Engineers Comments Regarding Surface Water Drainage

Application Reference:	M/38/26/HH	Reviewer Reference:	ADC/EXT5/AF
Planning Officer:	Susan Haley	Date of Review:	10/07/2026
Site Name:	4 North Avenue Middleton-on-sea PO22 6HF		
Application Description:	Single storey rear full-width extension and alterations to rear first-floor balcony.		
Assessment Number:	1

PROJECT	4 North Avenue PO22 6HF		CLIENT Goviden	
	SHEET Roof Plan		Date Issue Date	Scale (@ A3) 1 : 100
		Drawn by Checked by	SW SR	DRAWING NUMBER P 10
				REV

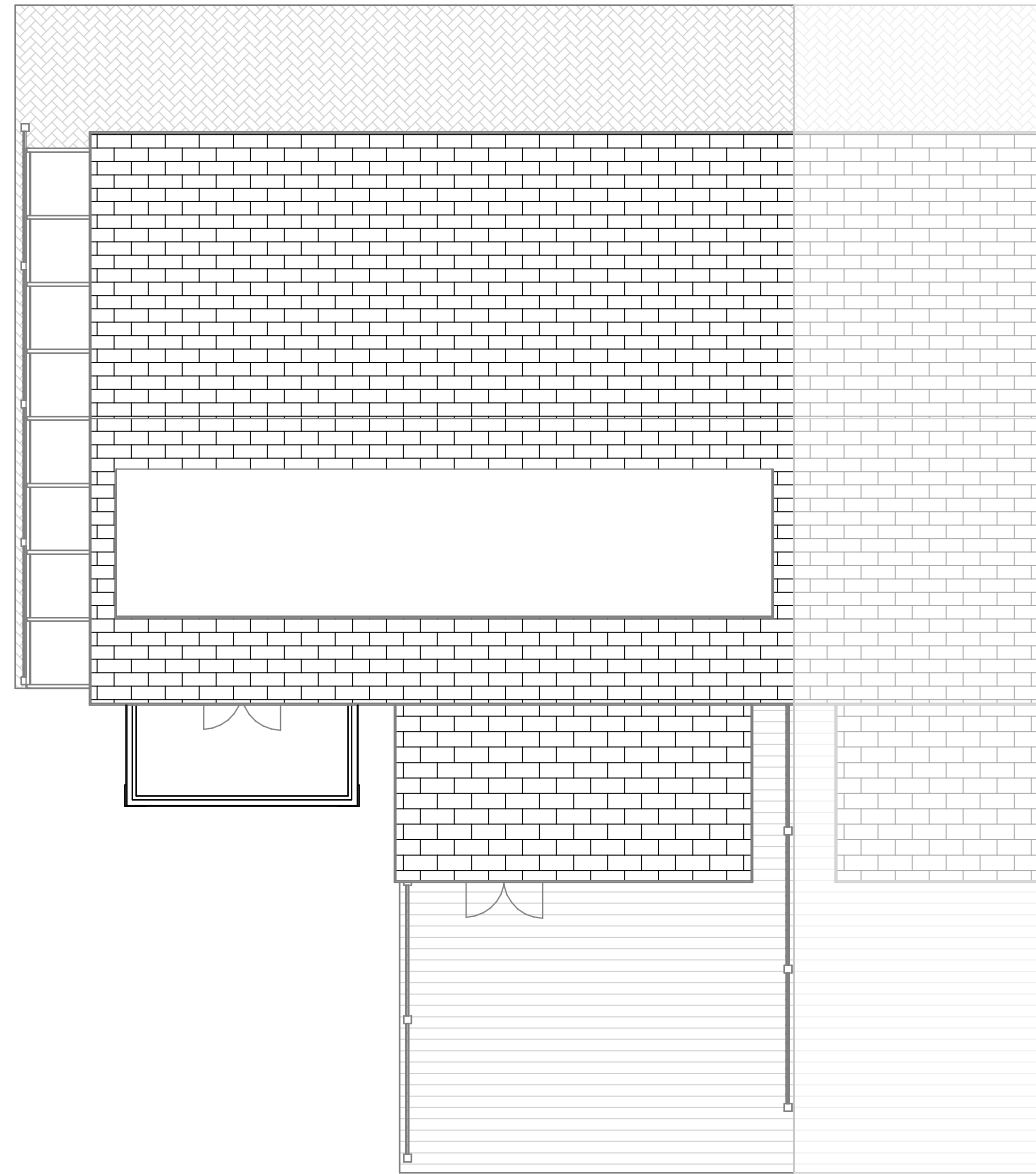
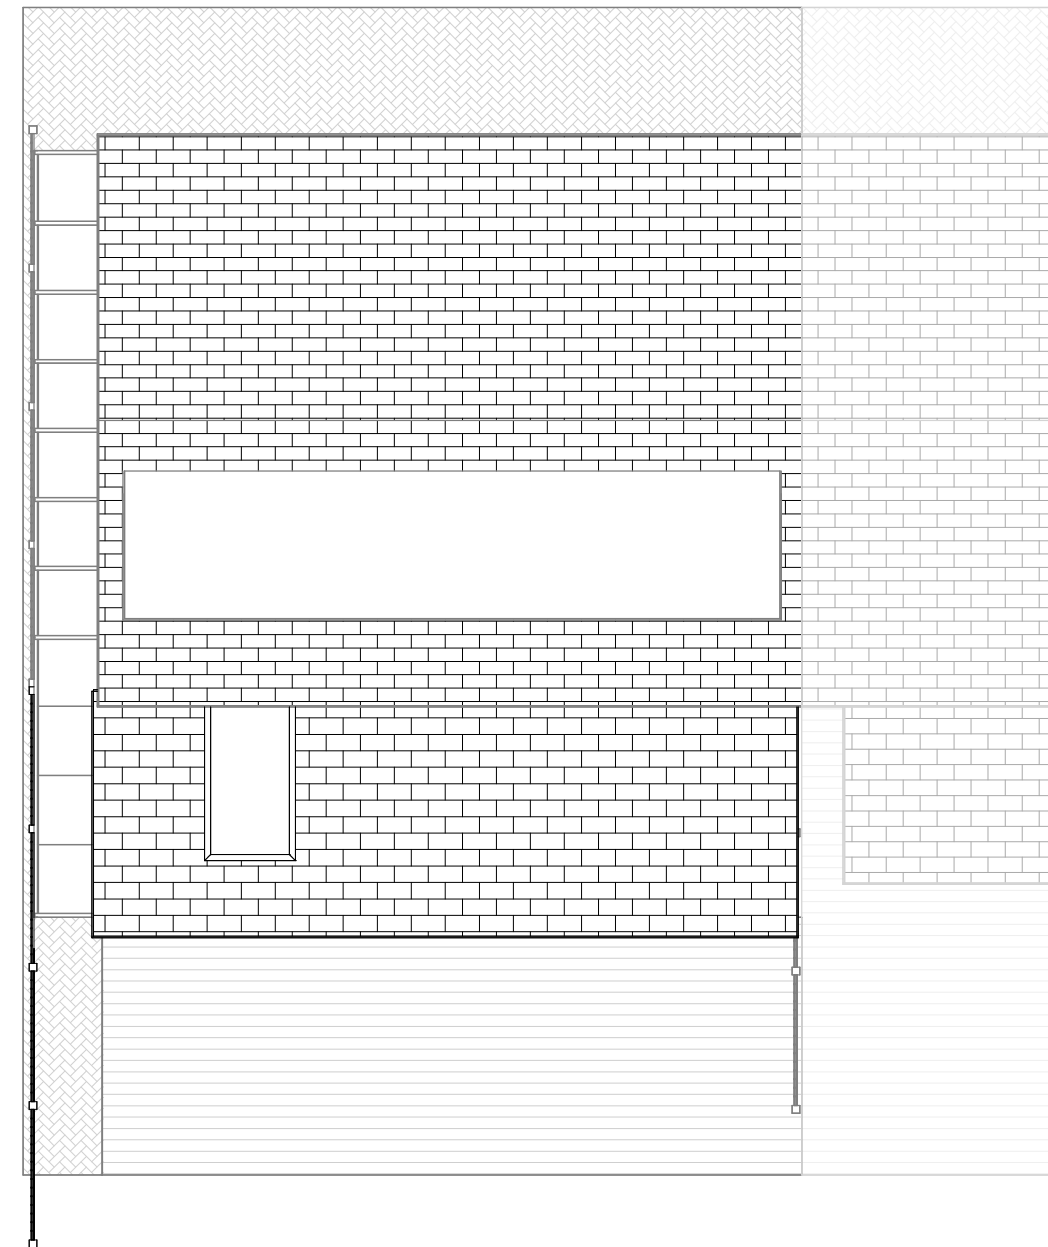
- 3.1. The outline calculations provided for the drainage system are not in accordance with sustainable drainage standards. The additional area should be attenuated, or the infiltration feature sized to accommodate large return period storms.
- 3.2. The drained area should be clarified and runoff calculated for the design storm based upon up to date rainfall data. Guidance is provided on ADC webpages - <https://www.arun.gov.uk/surfacewater>.
- 3.3. Management of extreme rainfall is not currently in accordance with the requirements of the NSfS Standard 3. Therefore, we **object** to the application.
